Please find our review of the SSD 8344 proposal for North Kellyville Public School.

The Department of Planning has asked the Government Architect NSW to provide independent design review commentary on State Significant Development application SSD 8344, North Kellyville Public School.

The application is for the construction of new school buildings. New landscaping, sports fields, signage and fencing is proposed.

SITE PLAN
SCALE 1:500

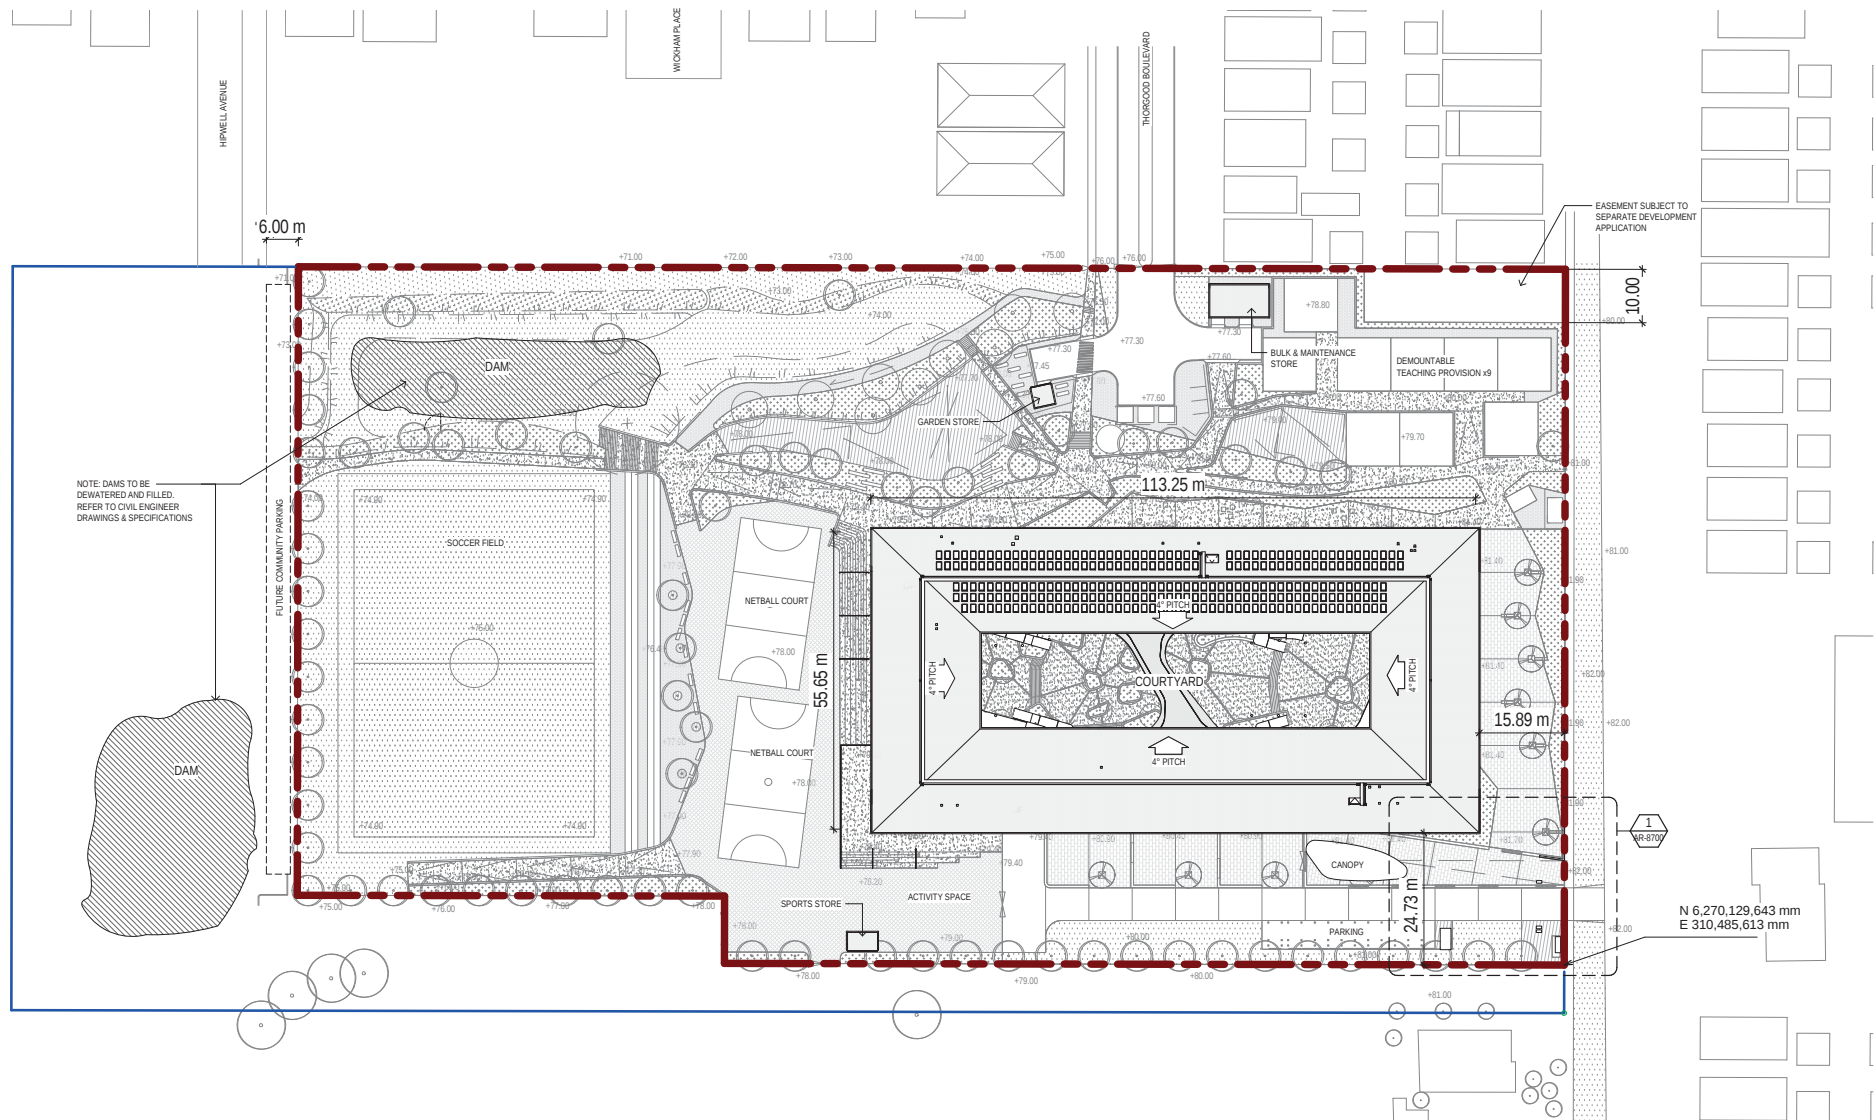
- A Site plan that describes the entry, parking and drop off zones with notes on how separation of vehicles and pedestrians will be achieved.
- Detailed plans and description of which parts of the school grounds can be made available for after school hours care and community use outside of school hours.

- Provide a shelter visible to the administration offices and the car pick up zone where students can wait out of the weather.
- Consider developing more articulation in the form as seen from the exterior, for example to provide opportunities to see through the building along the south elevation (over the entry) and to the east, or to demarcate the entry more strongly.
- A revised Landscape Plan is to be submitted showing boundary planting that is more resilient to shade, and ball sports and provides WSUD and wildlife support functions. Provide a detailed planting plan.

Bicycle parking is provided however it appears to be inadequate for 1000 students and teachers.

The main entry, as it faces towards the private boundary does not provide for passively supervised arrival and departure. No provision has been made for student pick up zones that provide shelter from rain or sun.

Client	NSW DEPARTMENT OF EDUCATION
Project	NORTH KELLYVILLE NEW PRIMARY SCHOOL
Title	BUILDING ELEVATIONS - WITH LOUVERS
Original Size	A1
Drawing No:	21-26108 - KN-SD - AR-3000
Rev:	G

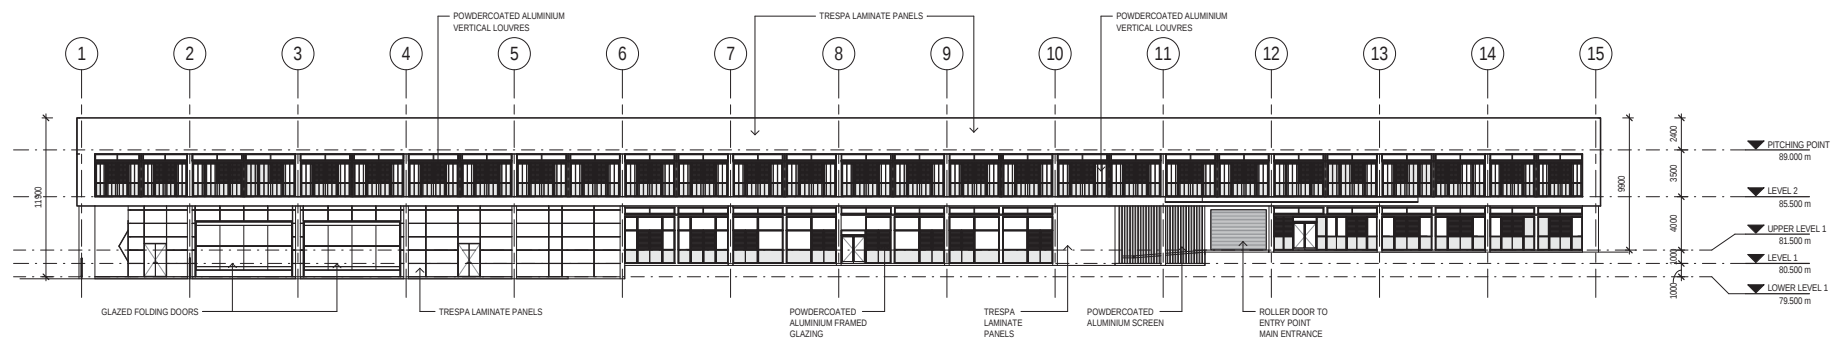
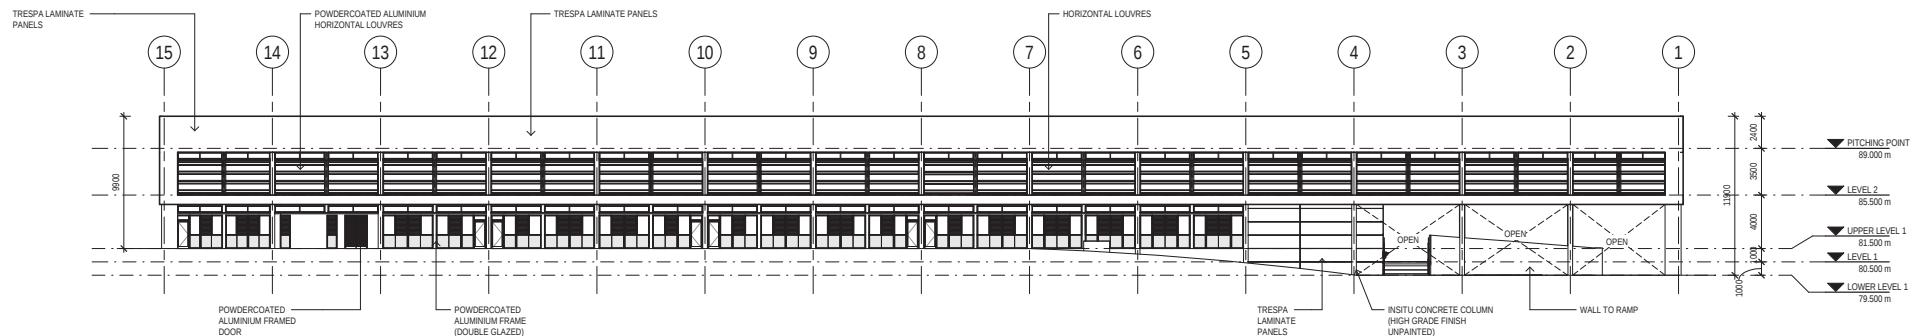
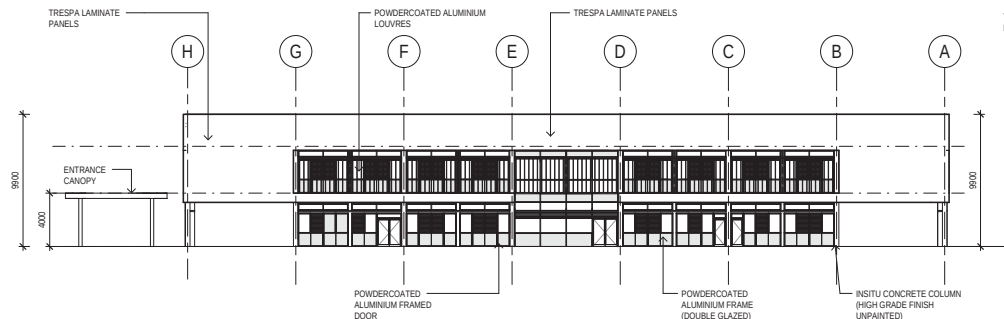
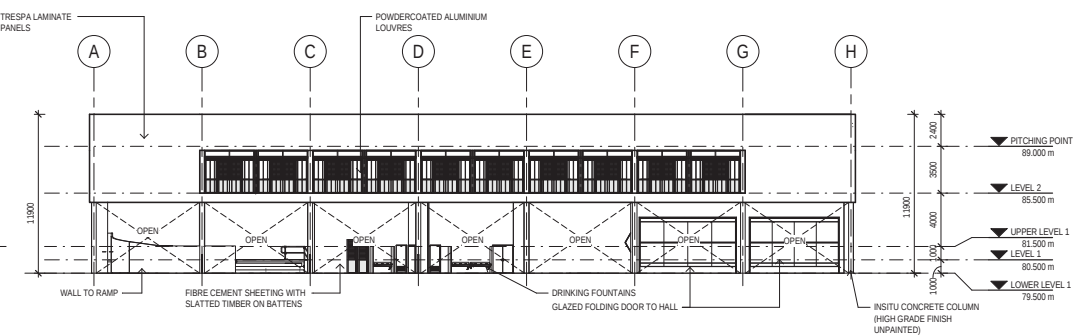
- Detail on sections and elevations which clearly show materials and detailing. Typical details of cladding and windows should be provided at 1:20
- Typical classroom plans showing furniture layouts with alternative arrangements demonstrating the flexibility of the spaces.

The proposal presents as a large institutional building, however the attention to detail in material, colour and planning demonstrates an appropriate playfulness and friendliness despite the scale of the elevations. Further development of the design should see some break up of the form to the south, over the entry and the east towards the street which will give some relief to the long stretches of elevation and roof. The internal courtyard provides amenity to the students and staff through all activities, which creates both a feeling of security and provides the opportunity for lightness to the internal facades.
